Our ref: WA/2019/127046/01-L01
Your ref: 19/01740/HYBRID
Date: 23 September 2019

Outline planning permission (all matters reserved except for access) for up to 23,400sq.m of B1 development (Use Classes B1a and/or B1b and/or B1c); highway works (including provision of a new roundabout at the junction between Vendee Drive and Wendlebury Road); creation of a wetland and landscaped areas; and associated infrastructure works. - Full planning permission for a health and racquets club, associated access and car parking, outdoor tennis courts, air dome, outdoor swimming pool, spa garden and terrace, and associated landscaping

Land Adj To Promised Land Farm, Wendlebury Road, Chesterton

Figure 7: Preliminary Flood Compensation Scheme 1 (Drawing No. S1358-Ext-35A)

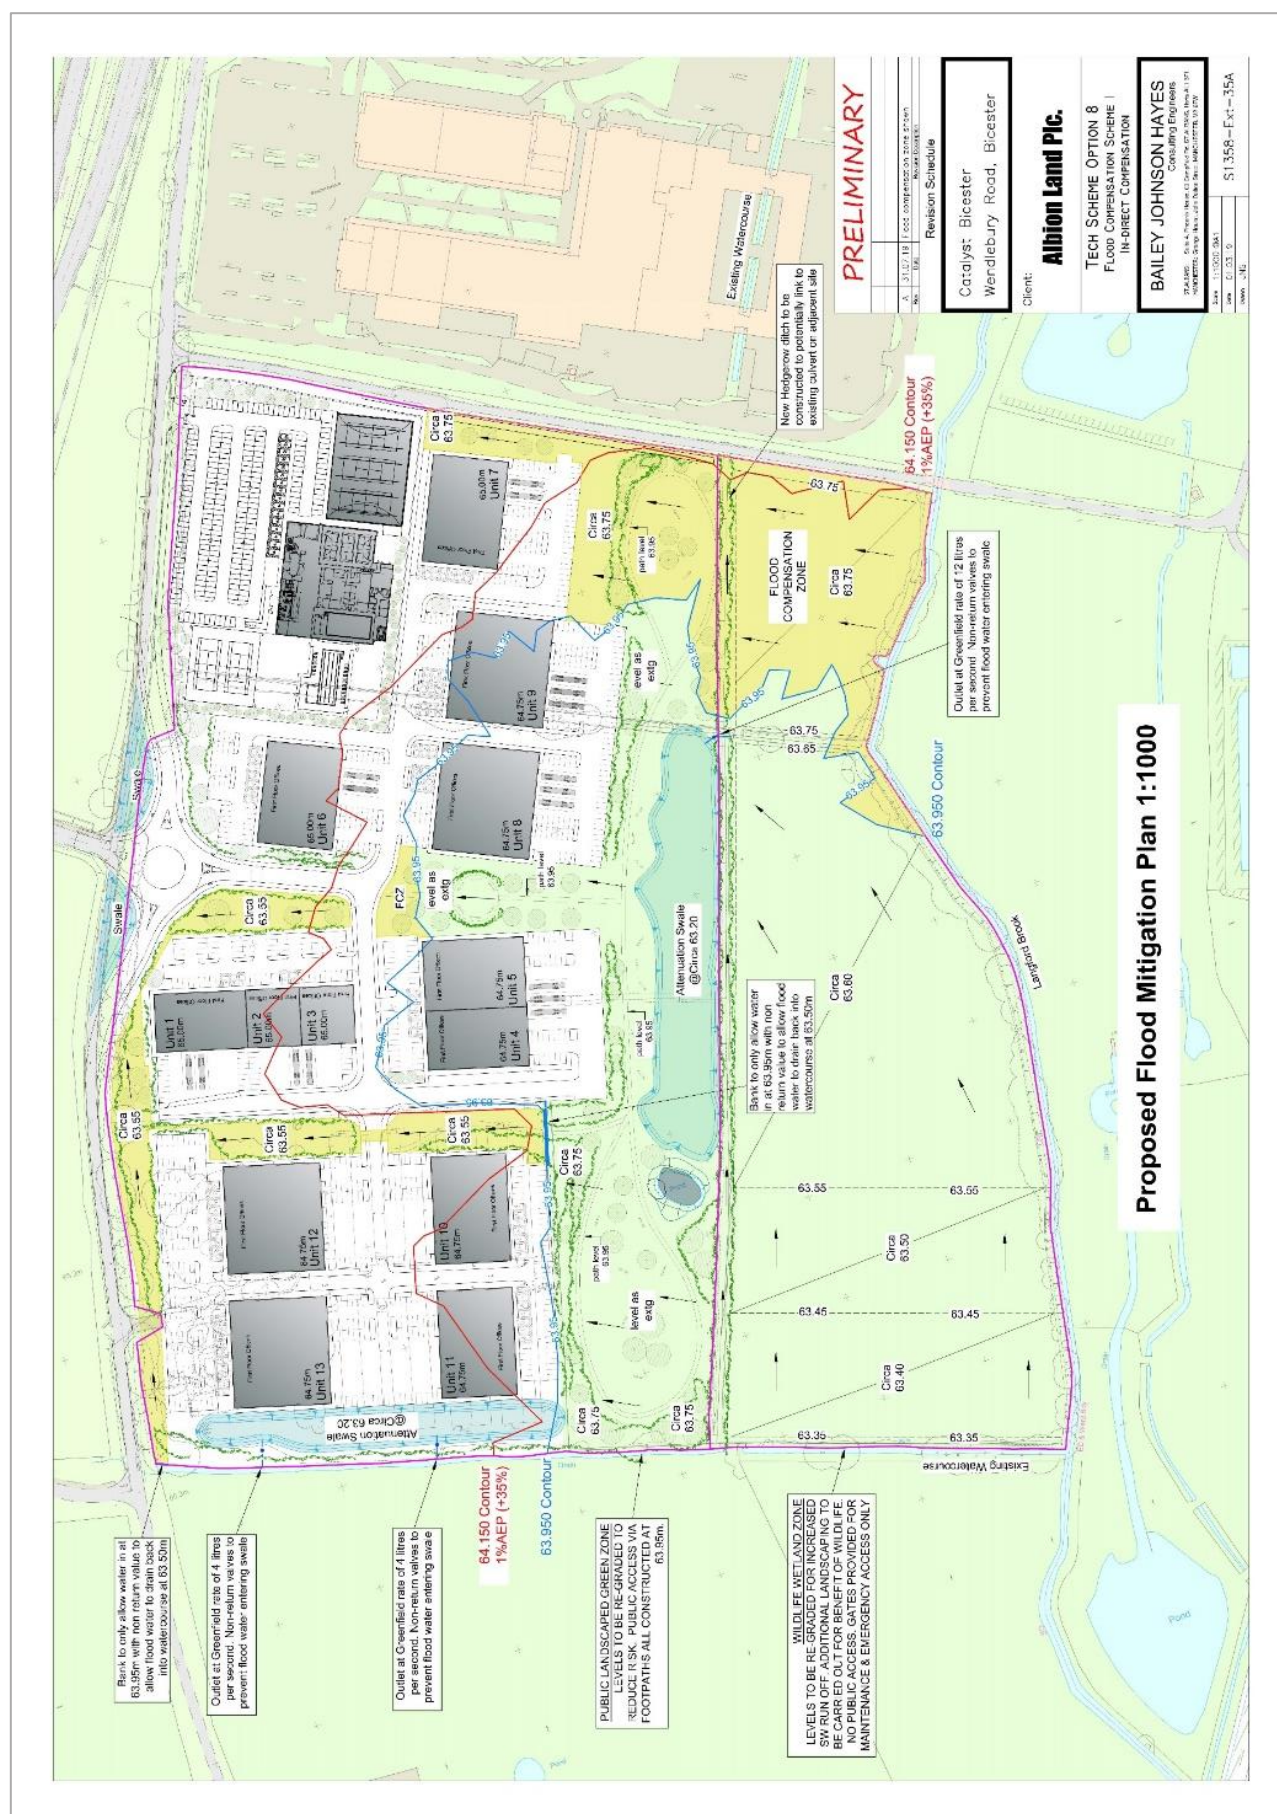
There is no detail in the FRA in respect of how much compensation is necessary for the loss of floodplain storage and how this can be incorporated into the site. We expect flood compensation to be provided on a level for level basis up to the 1 in 100 plus 35% flood level. This detail is something we are unable to condition as we need to know that level for level compensation is achievable before outline permission is granted.
